# CITY OF ALBUQUERQUE

**RE: Kumail Subdivision, (C-19/D040)**  
**Engineers Certification for Release of Financial Guaranty**  
**Engineers Stamp dated 1/03/2005**  
**Engineers Certification dated 01/31/2008**

**Re: Kumail Subdivision Grading and Drainage Plan**  
**Engineer's Stamp dated 1-3-05, (C19/D40)**

**Re: Kumail Subdivision Grading and Drainage Plan  
Engineer's Stamp dated 9-7-04, (C19/D40)**

CITY OF ALBUQUERQUE PUBLIC WORKS DEPARTMENT ENGINEERING GROUP	
TITLE: KUMAIL SUBDIVISION GRADING AND DRAINAGE PLAN	
DESIGN REVIEW COMMITTEE	QTY ENGINEER APPROVAL
LAST DESIGN DATE	MO./DAY/YR.
PROJECT NO.	MAP NO. C-20
SHEET OF

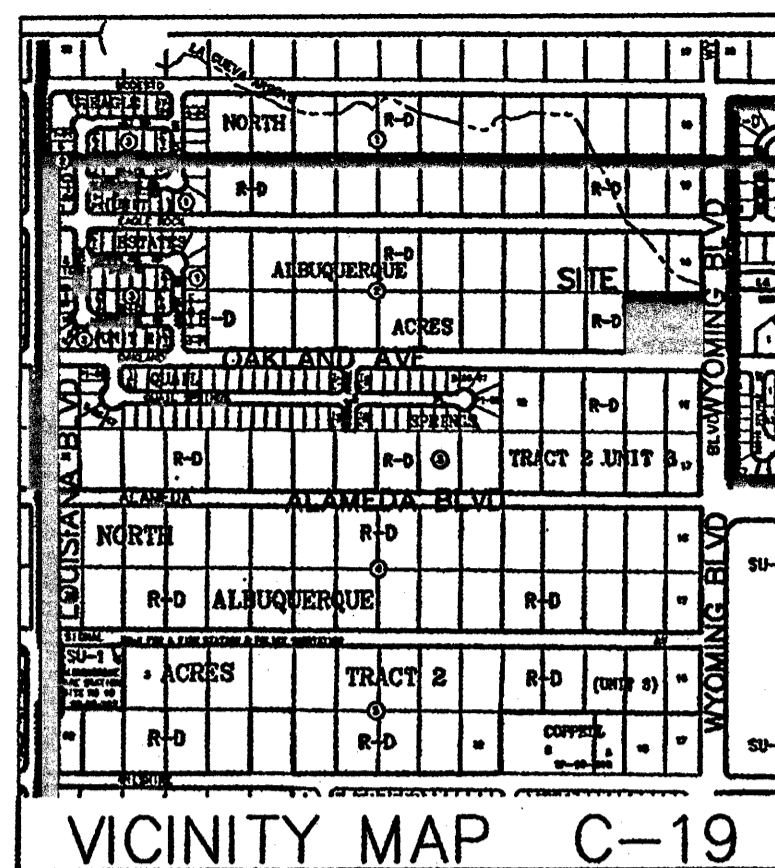
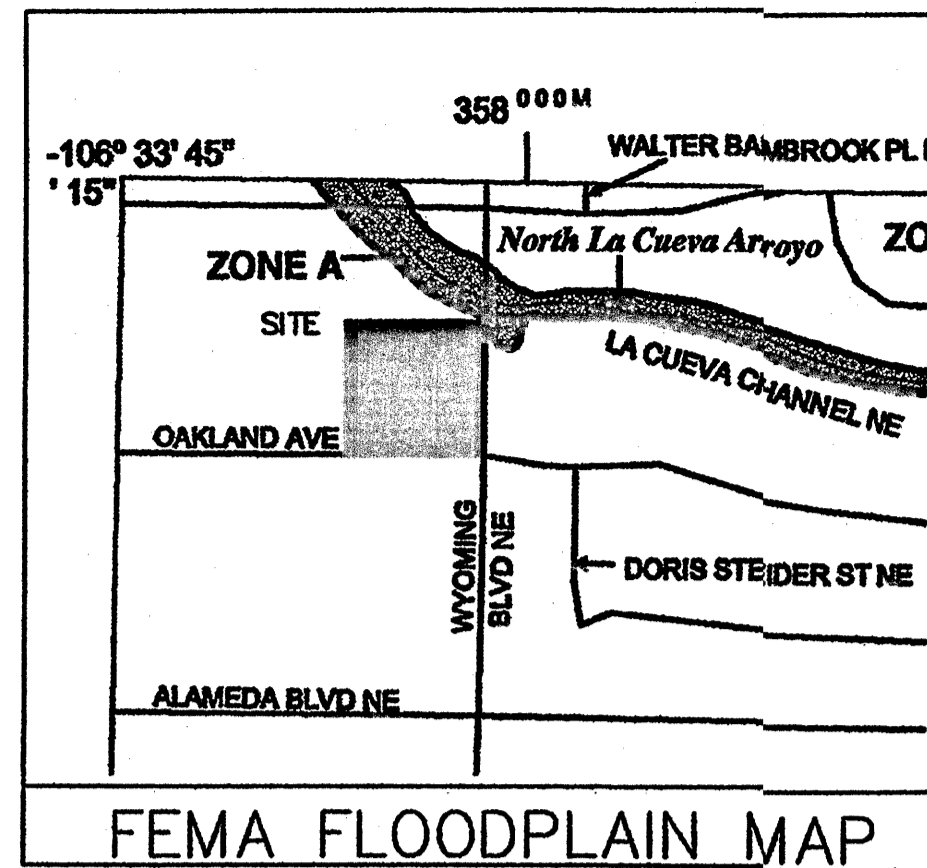
- Please provide design grades for the subdivision to the west in order to compare elevations at the west property line.

- Please provide lot numbers and all required spot elevations. There are a number of them missing from the southeastern lots.

- It appears that a retaining wall will be required between the pad and the swale on the southwesterly lot. The northwesterly lot should drain to the street. The 5' channel on the west must be hardlined. Is it really necessary?
